Champs Fresh Food
8909 US-401
Fuquay-Varina, NC 27526

Re: BCOM2311-0004 (revision submitted 10-2-25)

The resubmitted plans, specifications and application resubmitted to Central Permitting on 10-2-25, are approved with the following conditions:

PROPOSED LAYOUT

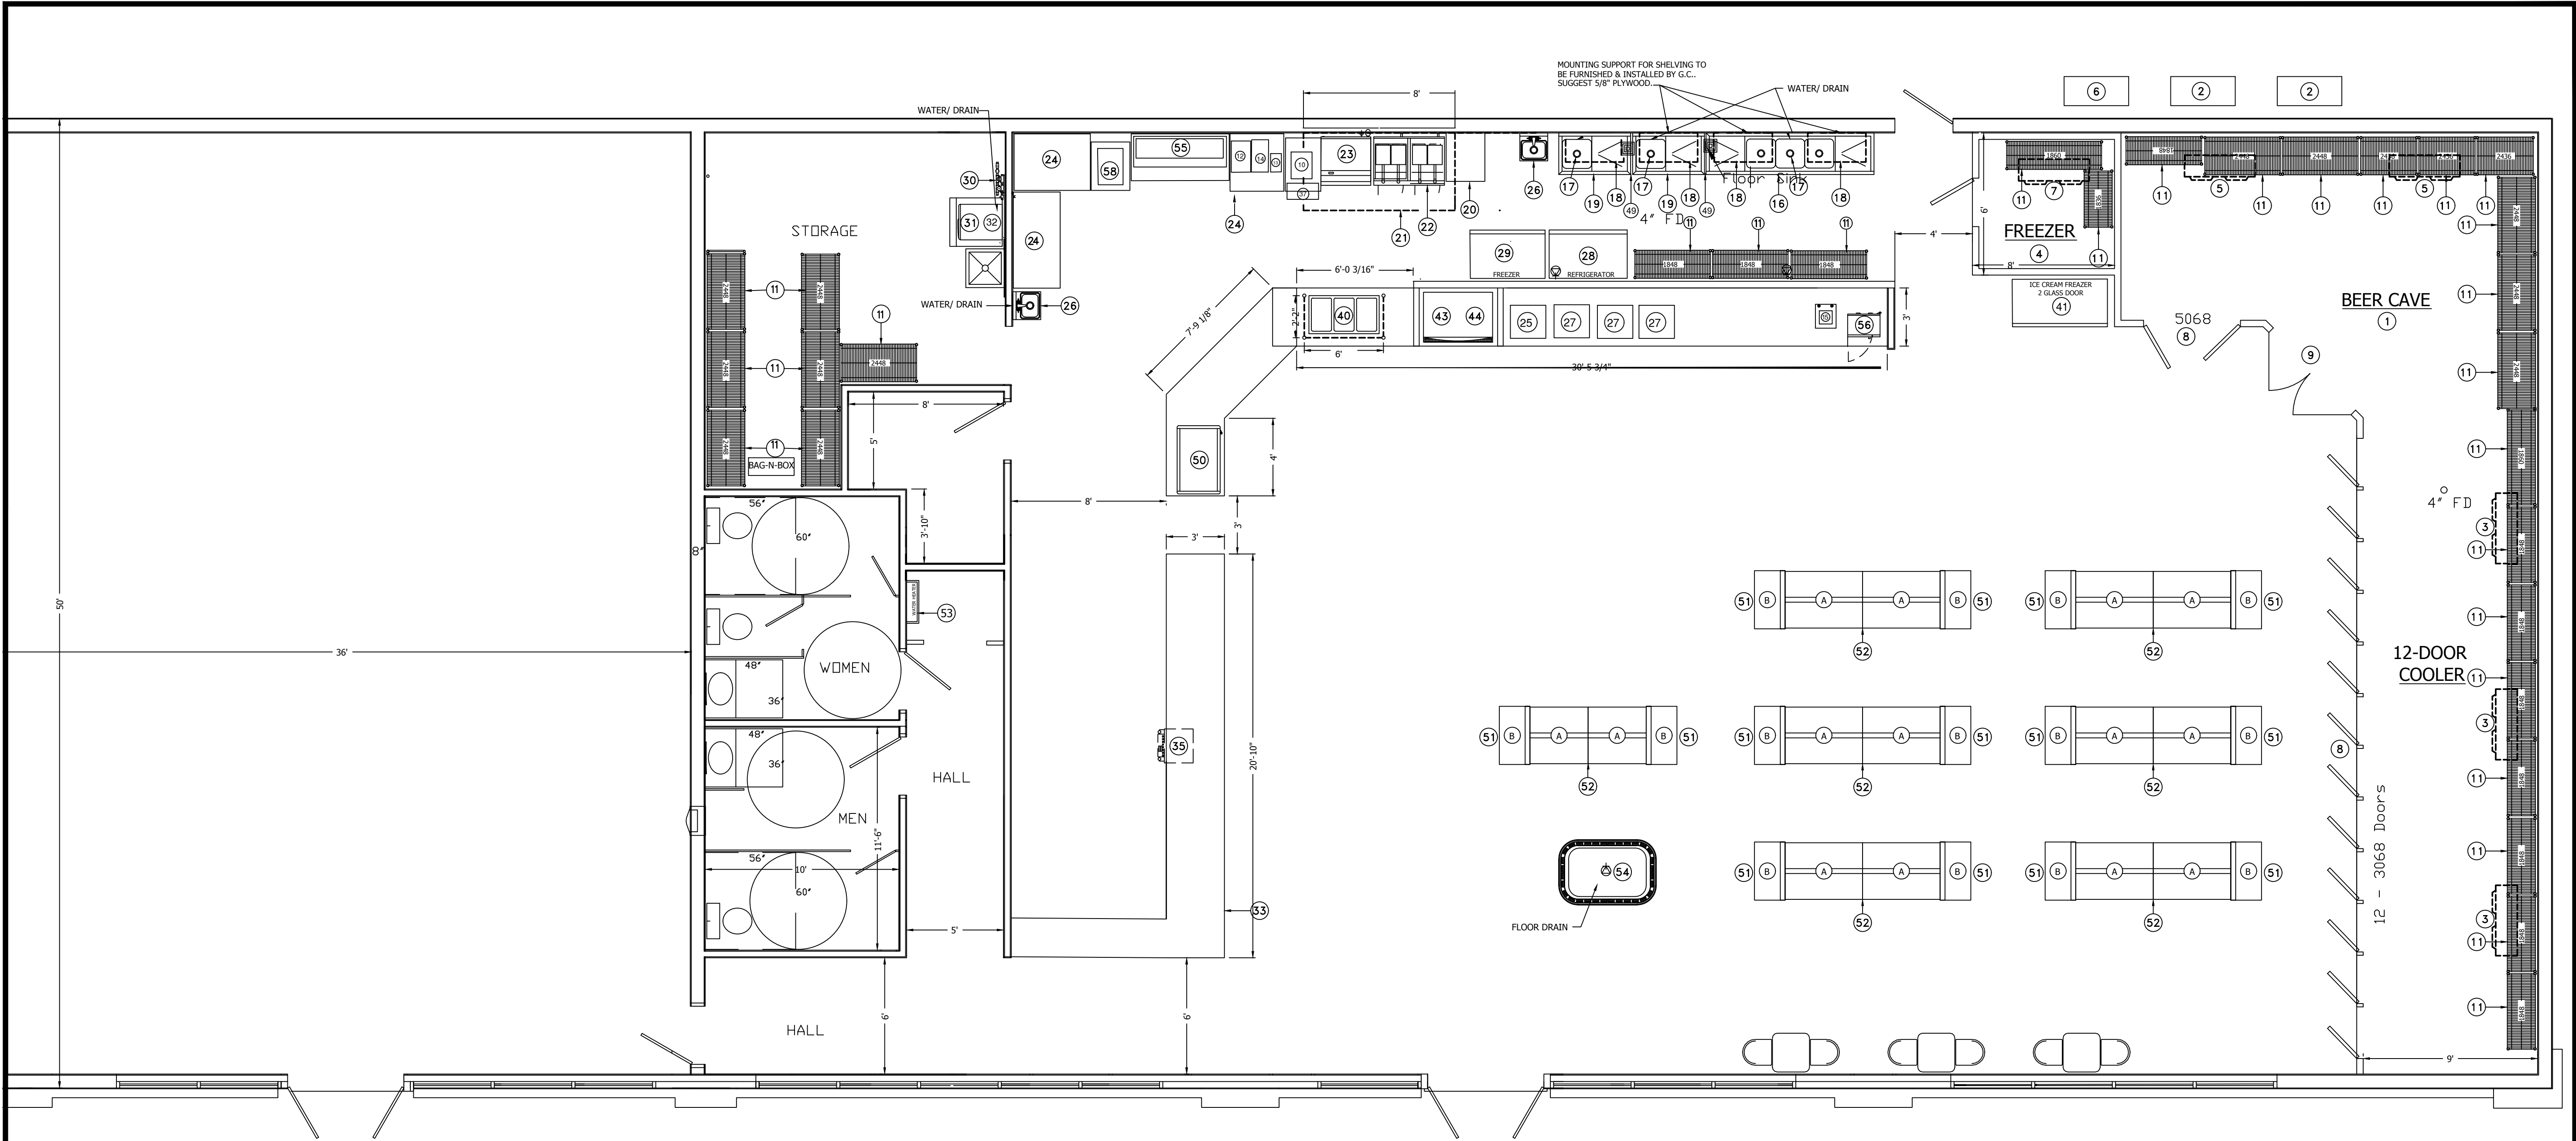
1. Splashguards shall be integral to handsinks or positioned at prep sinks and dish sink to be effective and adequately sized to eliminate contamination to food and utensils.

2. Finishes shall be smooth, non-absorbent, and easily cleanable. Floors, walls, and ceilings shall meet requirements as set forth in the NC Food Code 6-101.11 and 6-201.11.

3. Lighting shall meet minimum requirements as set forth in NC Food Code 6-202.11 Light Bulbs, Protective Sheilding and 6-303.11 Intensity.
4. Hot water demands shall meet 5-103.11 and 5-103.12 of the NC Food Code.

5. All equipment, including cabinetry and counters must comply with 4-205.10 of the NC Food Code and be installed as specified in 4-402.11 and 4-402.12. All food on display or otherwise exposed to the public will be protected by shields, dispensers or packaging.
